Stonestreet Green Solar

Appendix 1.2: EIA Scoping Opinion

Proposed Stonestreet Green Solar

30 May 2022

Produced:	Checked:	Date:	Version:
RC	Quod	May 2024	01

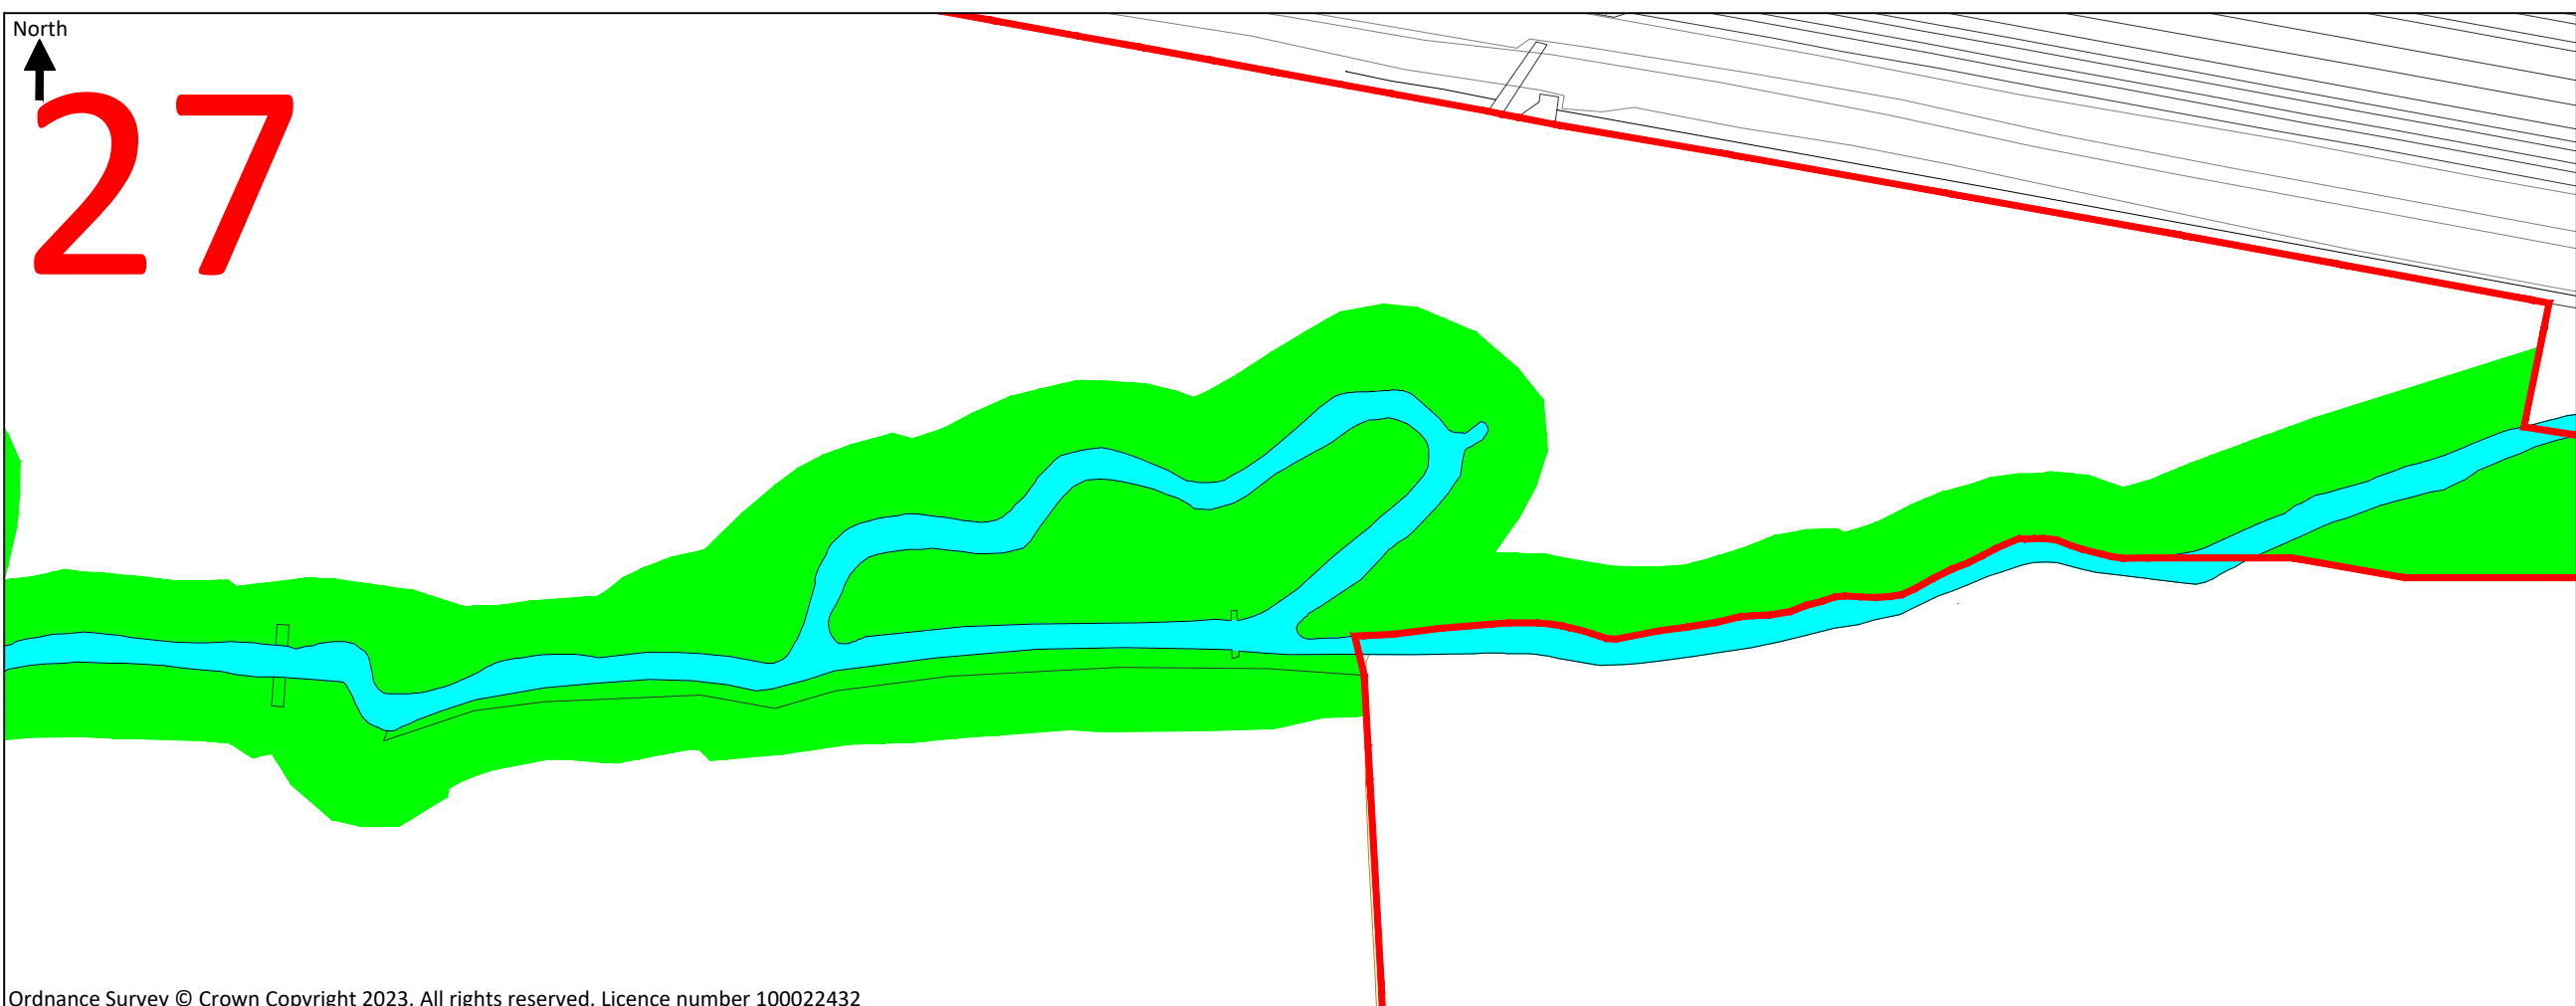
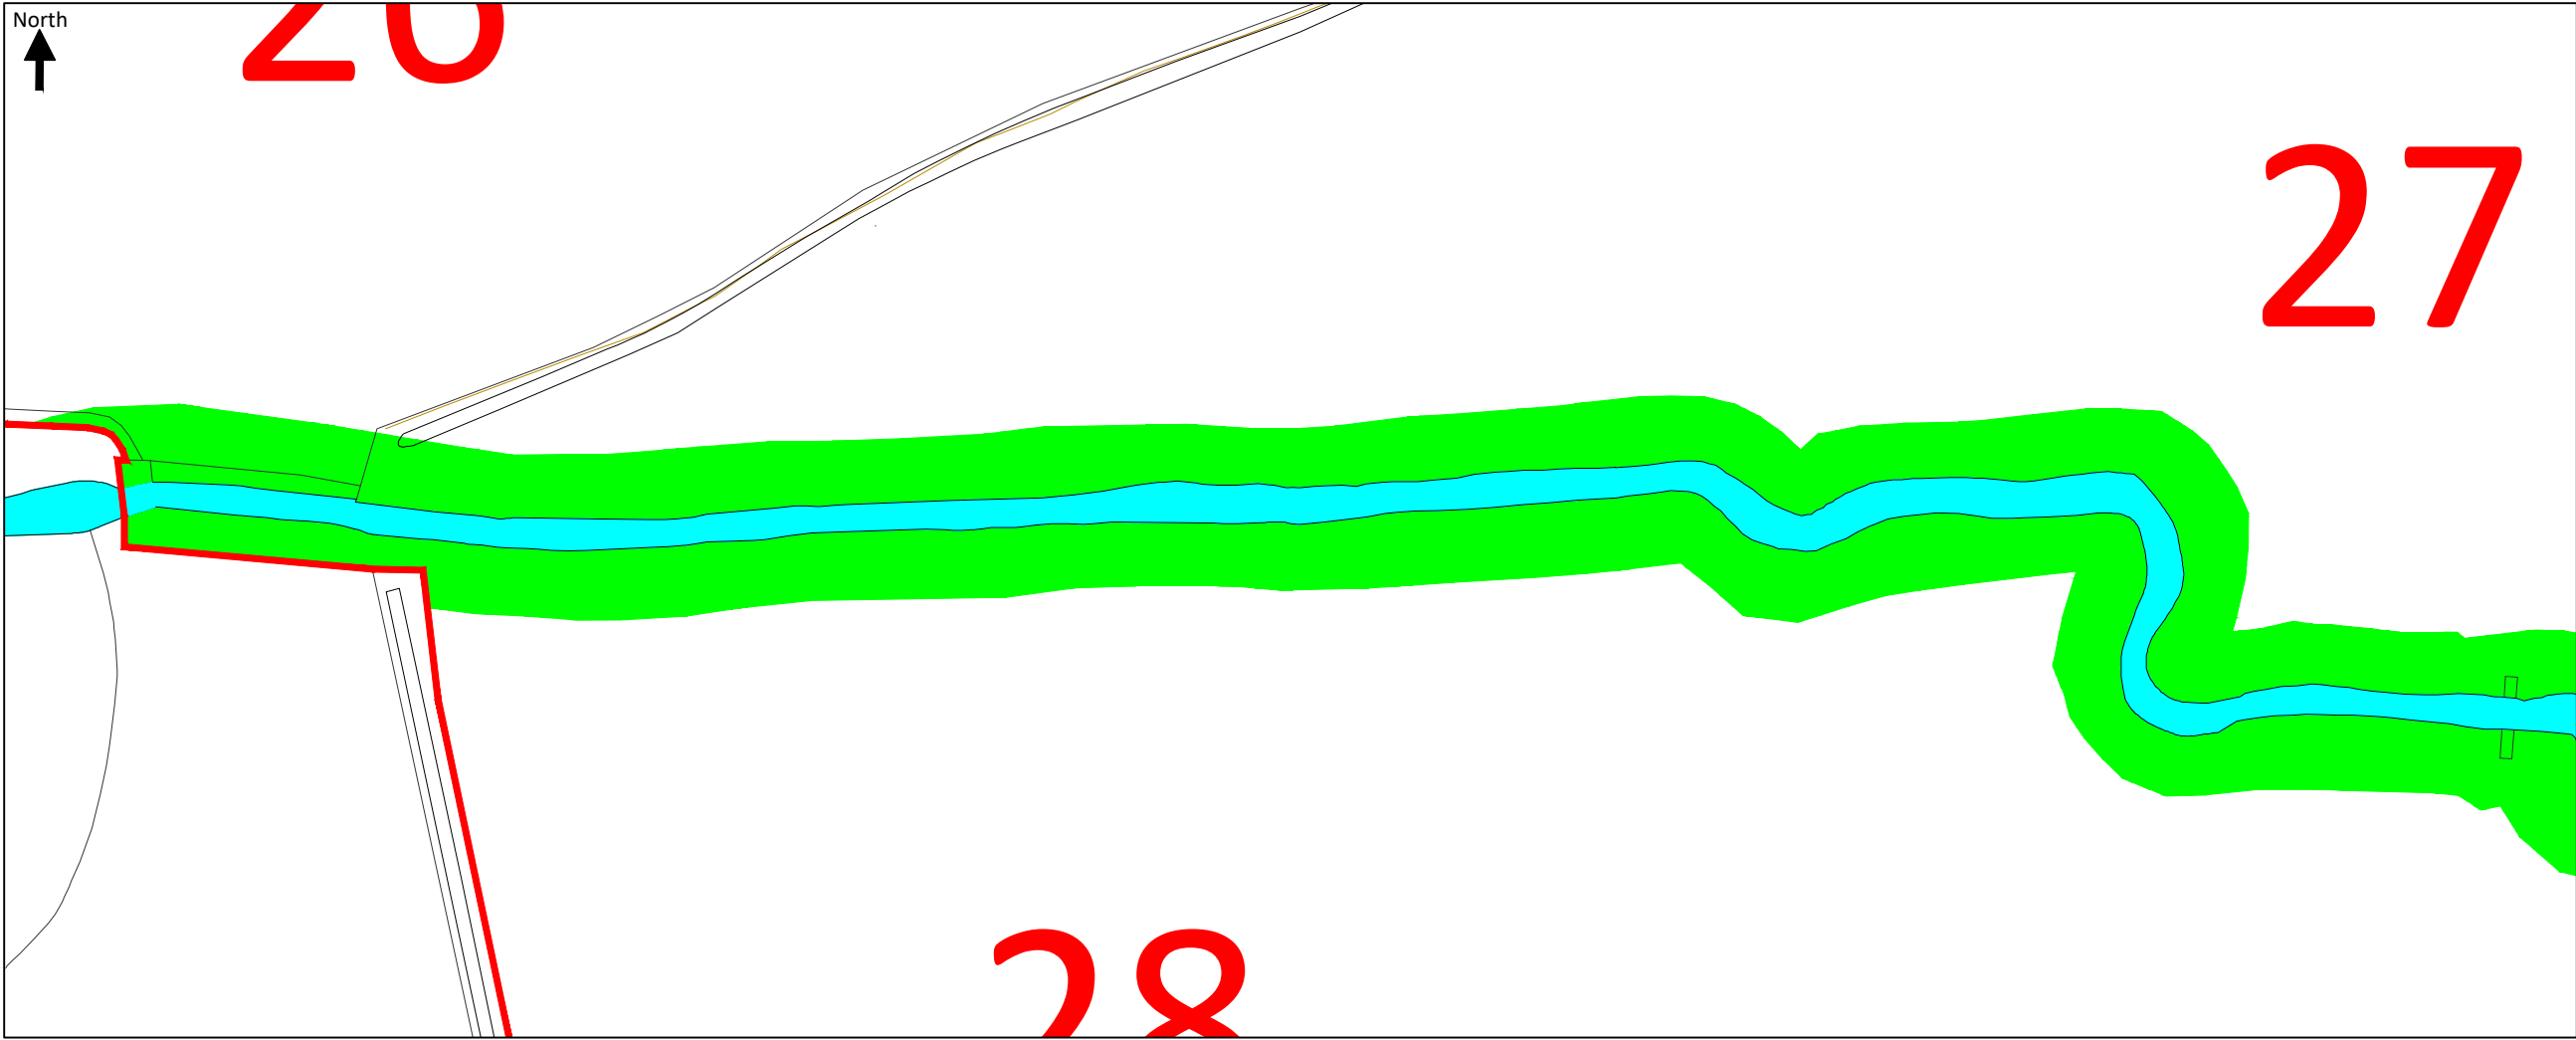
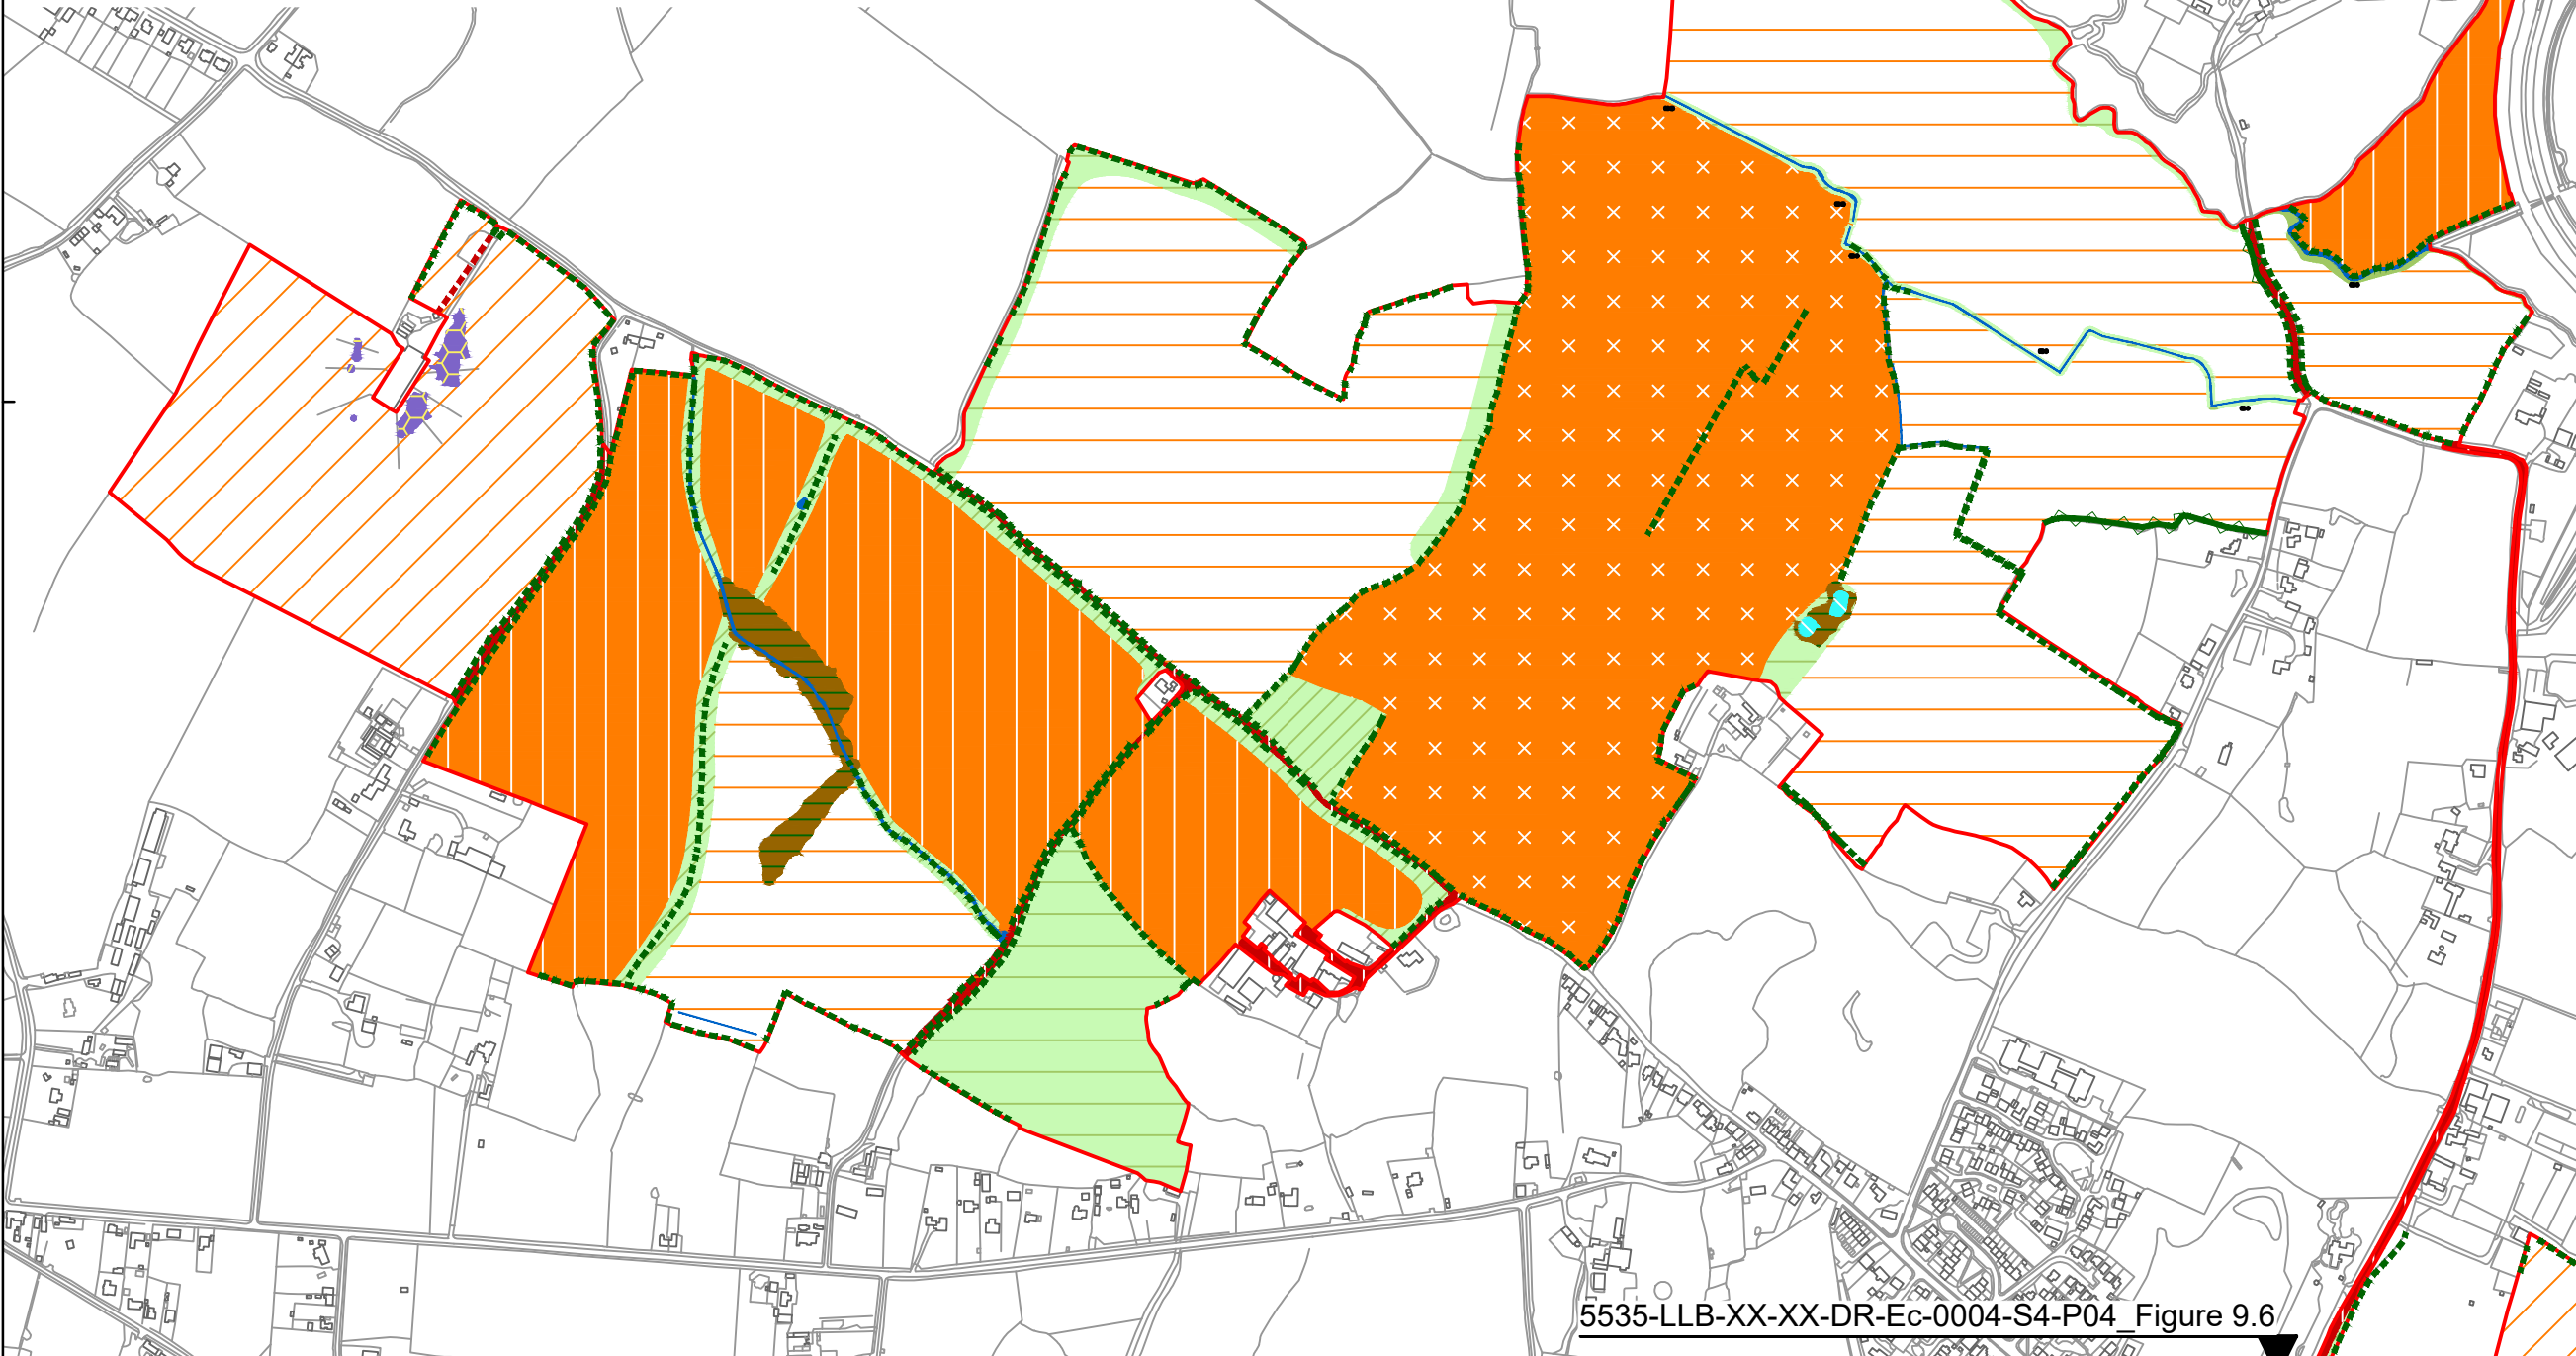
3.4.6	10.7.9, 11.3.3, 11.3.2, 11.5.1 and Table 10.3	East Stour River habitat of Principal Importance	<p>Figure 12 and paragraph 1.4.5 identify that the East Stour River runs directly through the solar array site. Scoping Report paragraph 10.7.9 proposes to scope out impacts to the East Stour River on the basis that standard construction measures secured through the CEMP will afford physical protection and pollution prevention and control; this includes a 10m standoff distance between any built development and watercourses and pollution control measures.</p> <p>Scoping Report paragraphs 11.3.2 and 11.5.2 state that there is potential for watercourse crossings but these are not described in the project description and it is unclear whether potential crossings are for vehicles, cable routing etc. Without details of what crossings are proposed, the Inspectorate cannot agree to scope out consideration of impacts on the East Stour River.</p>

ID	Ref	Applicant's proposed matters to scope out	Inspectorate's comments
			The ES should describe and locate all proposed watercourse crossings and assess associated impacts where significant effects are likely to occur.
